**Wallerawang Quarry MOD 2 (DA 344-11-2001) – Request for Comments and Recommended Conditions of Consent**

The Wallerawang Quarry is an open cut operation located approximately 4 kilometres from Wallerawang, NSW. The Wallerawang Quarry MOD 2 proposes a 12 months time extension to the existing Development Consent. Quarrying operations at Wallerawang Quarry are currently permitted to 15 July 2019. The Modification seeks to extend this to 15 July 2020.

Figure 7
MODIFIED FINAL LANDFORM

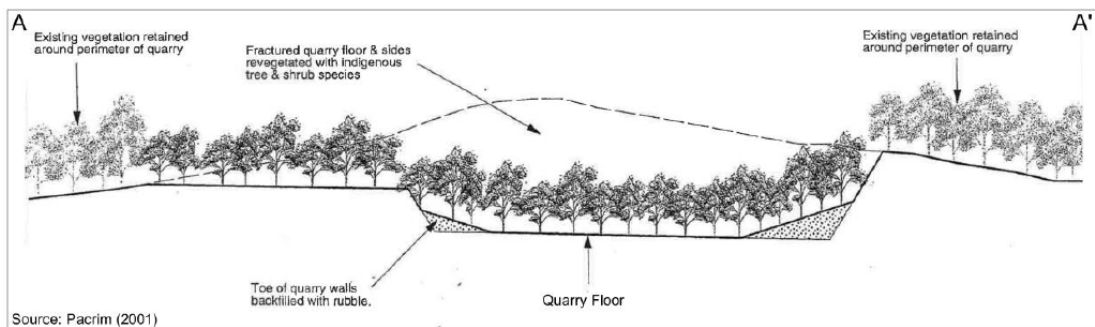
The Resources Regulator notes an inconsistency in the SEE which may require clarification by the proponent. Specifically, the statement that MOD 2 will;

- “not require any changes to the approved operations and... would not result in any additional impact on the biophysical environment”,

appears inconsistent with changes in Table 5 – Summary of Rehabilitation, of the SEE which identifies that changes during the extended Mining Operations Plan (MOP) period will be:

- An increase in Domain 6I – ‘Open Cut Void – Final Void’ size from 1ha to 2ha.
- A decrease in Domain 6E – ‘Open Cut Void – Woodland’ size from 3ha to 2ha

- A decrease in Domain 9 - Conservation and Biodiversity Offset Areas from 27.3 ha to 26.3ha (Note - it appears this may be a duplicate area to the Domain 6E decrease, above).

The Resources Regulator requests that condition 31 of DA 344-11-2001 be modified to ensure a revised Rehabilitation Management Plan (or equivalent Mining Operations Plan) be submitted to the Resources Regulator for approval within three months of the determination of Modification 2, unless the Secretary agrees otherwise;
